Lead Local Flood Authority
Post Point CHN 215
Hertfordshire County Council
County Hall, Pegs Lane
HERTFORD SG13 8DN

Date 22 January 2021

RE: 6/2020/3369/FULL – Lighting Packaging Supplies, Frobisher Way, Hatfield, AL10 9TY

**SITE PLAN**  
1.500

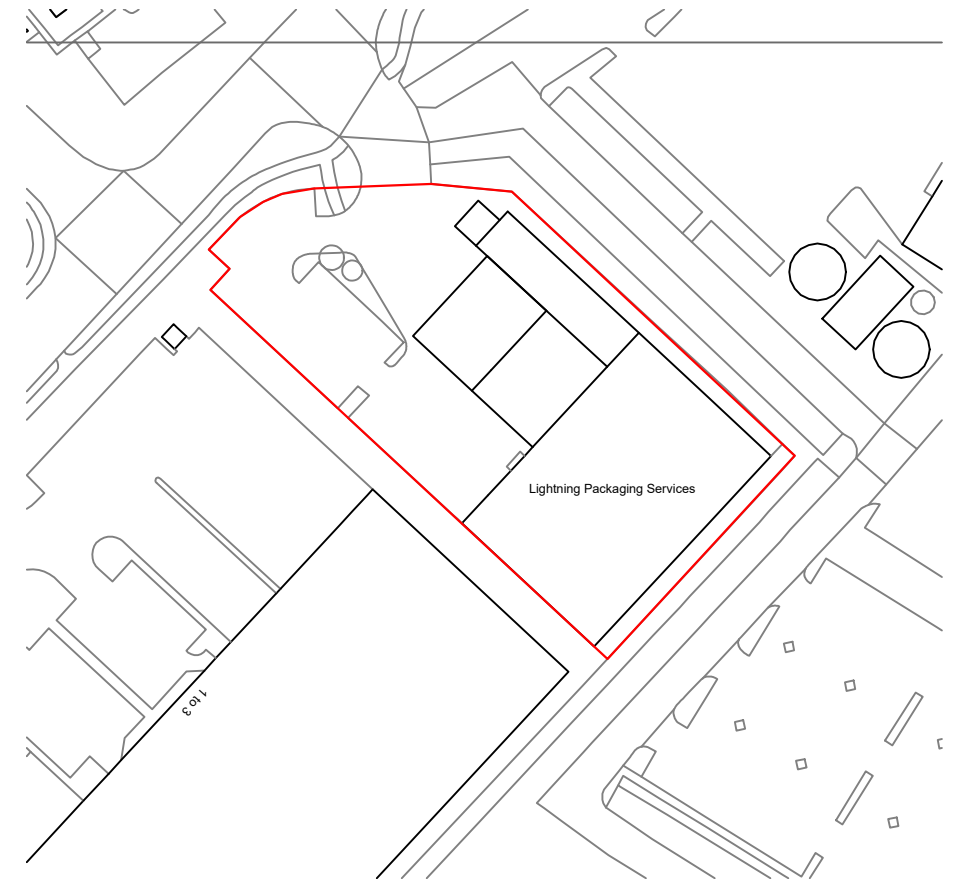
We understand from the application form that the surface water drainage discharges into an existing watercourse. We note however that there are no watercourses within close vicinity to the site. Drainage information should be submitted in support of the application to provide evidence that there is no increase in flood risk on or off-site from the works taken place as well as proposed. We also note that there is some potential for surface water flooding in the areas where the canopies are proposed.

The applicant should clarify if there is an existing system, how it works and if it is intended to be used. The applicant must demonstrate where the surface water discharge goes from the site and if it is restricted or not. If restricted to what rate is the discharge restricted. As the LLFA we need to ensure that all opportunities to improve the situation on site and in the surrounding of the development have been considered.
